RE: 2025/92388 (JCNAS 209837) | Red House Museum, 281 Oxford Road, Gomersal, BD19 4JP (Grade II*, c.1660, with C18, C19 and C20 alterations). Application for subdivision into two residential units and conversion of barn and coach house into third residential unit.

Thank you for consulting the Victorian Society on this application. Having considered the proposal carefully, we **raise serious concerns** to these plans in their current form.

Barn
Ground & First Floor Plans as Proposed

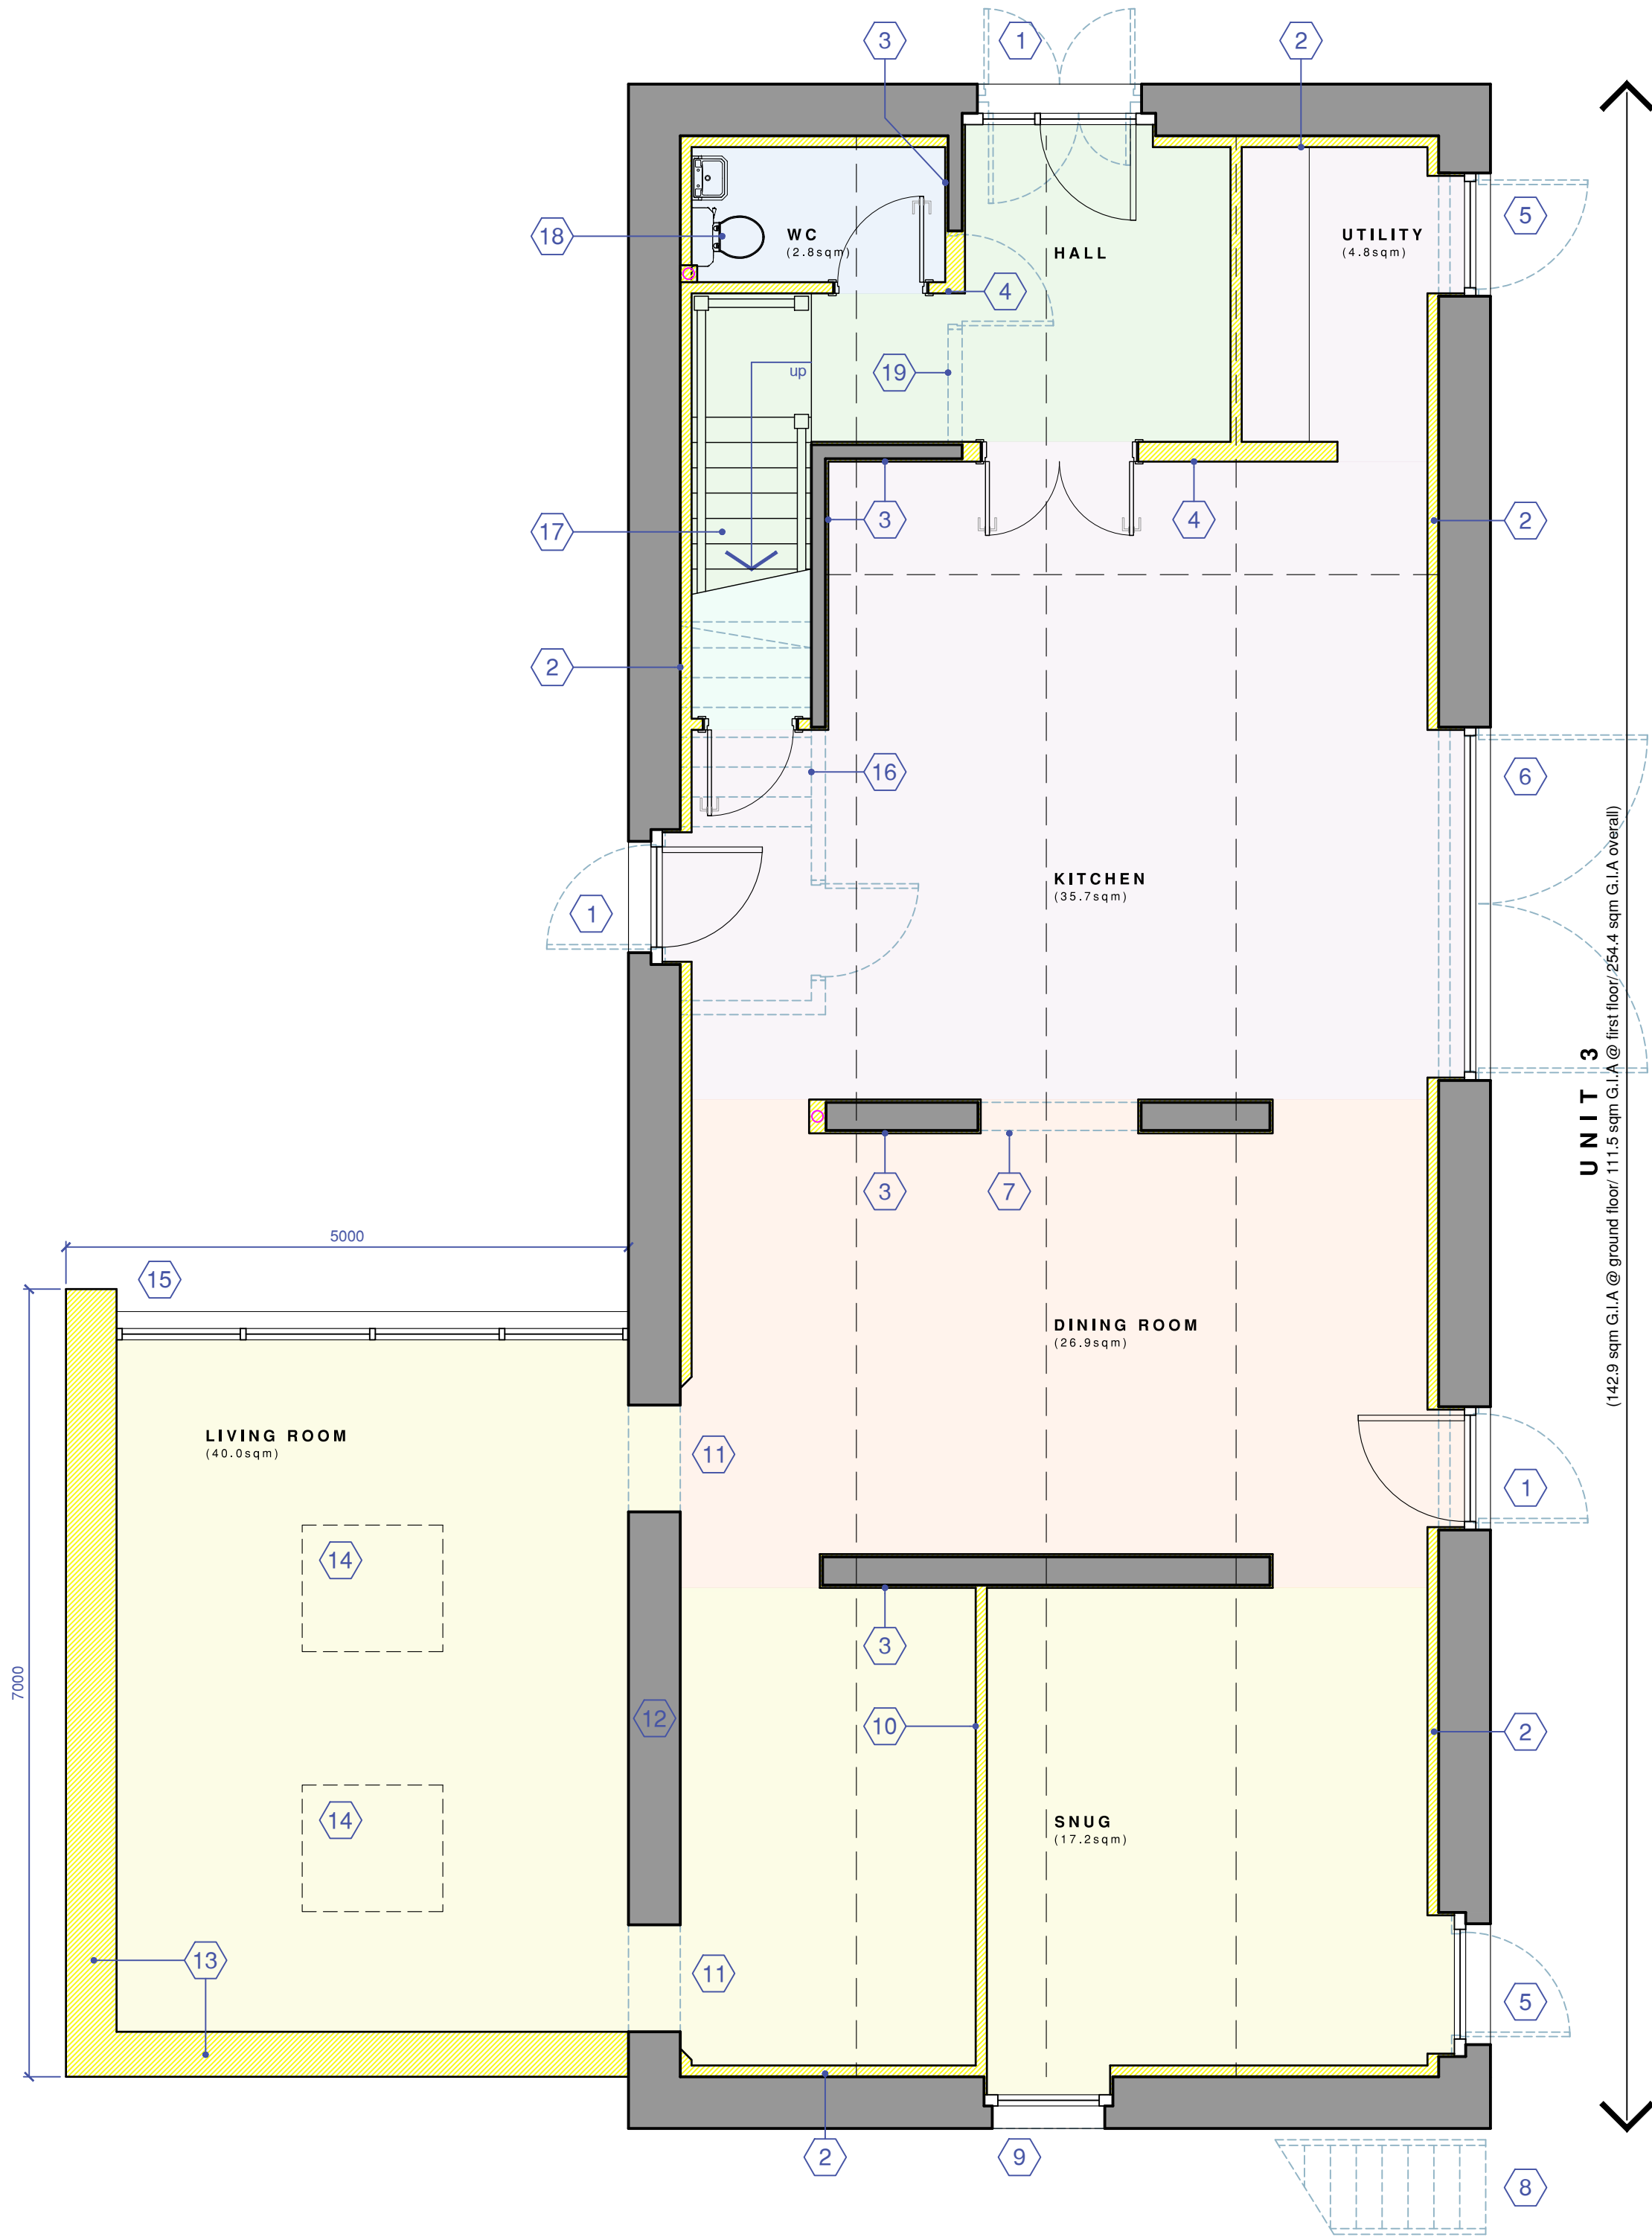
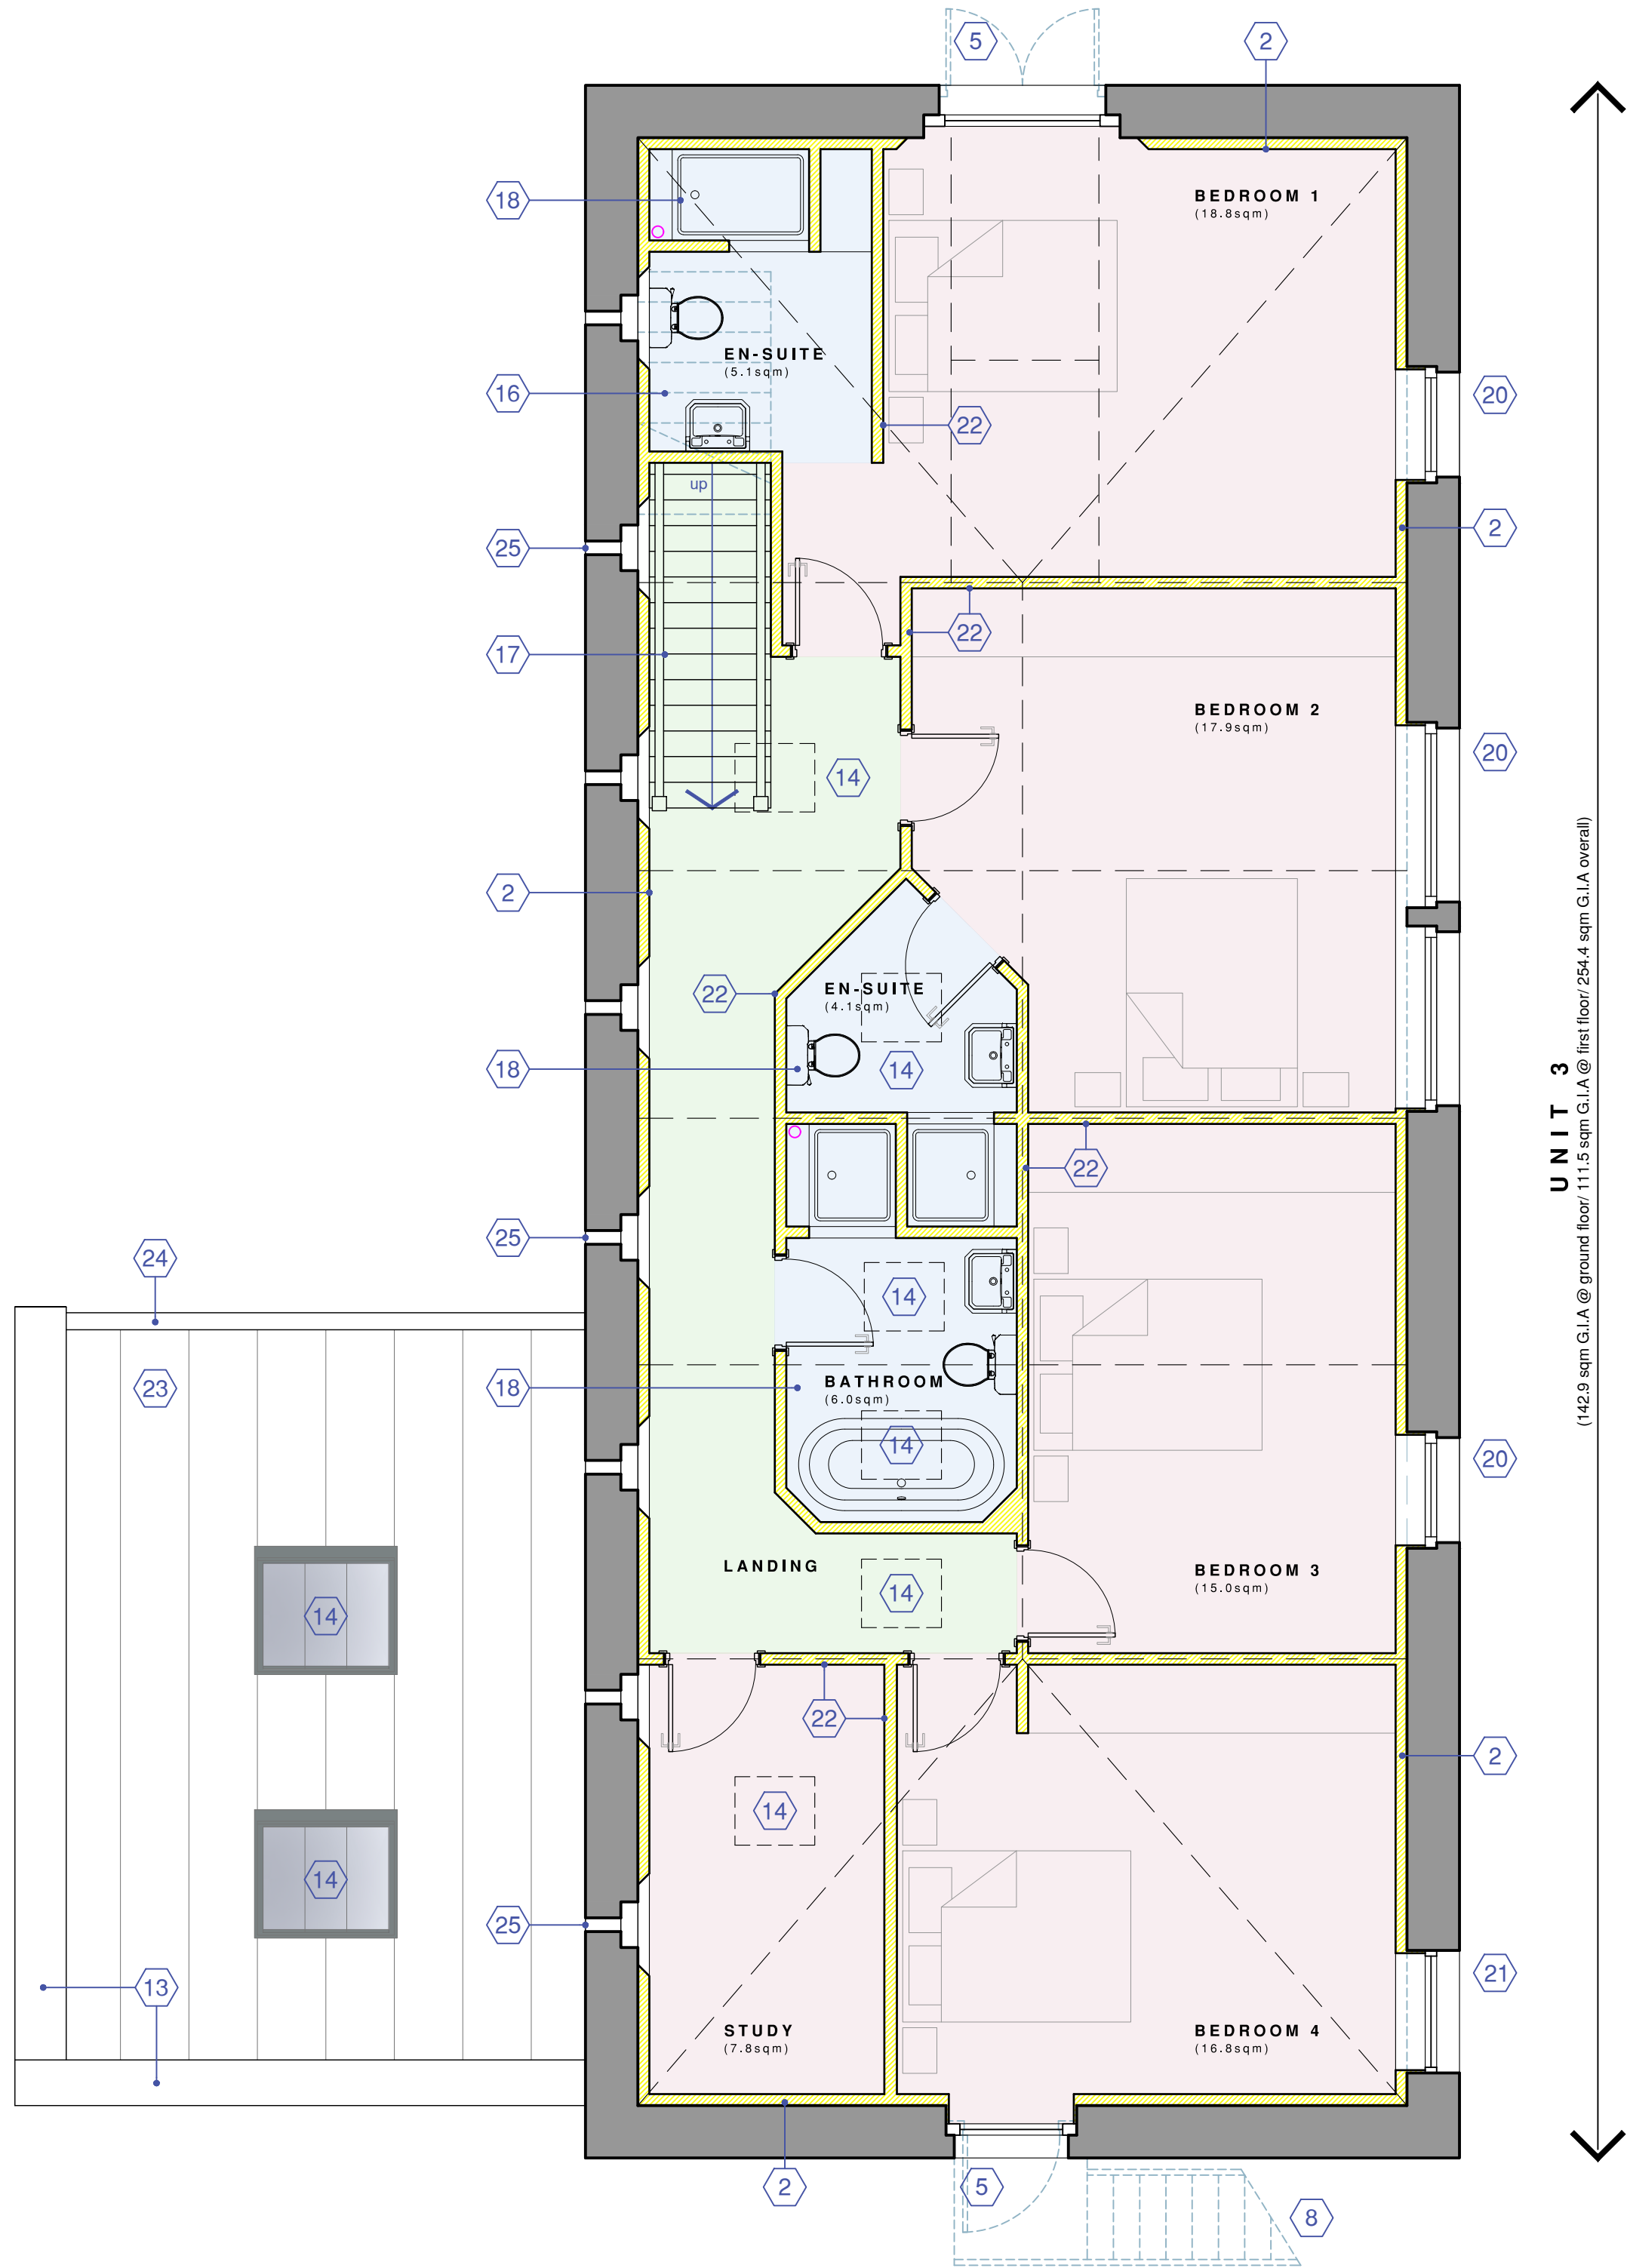
While we do not object to the principle of converting the barn and coach house into residential accommodation, we are concerned that they have not been treated as curtilage to the property and therefore lack the detail the alterations would require. We again request a deeper exploration of the impacts these proposals would have on the fabric, setting and relationship between the barn/coach house and main house.
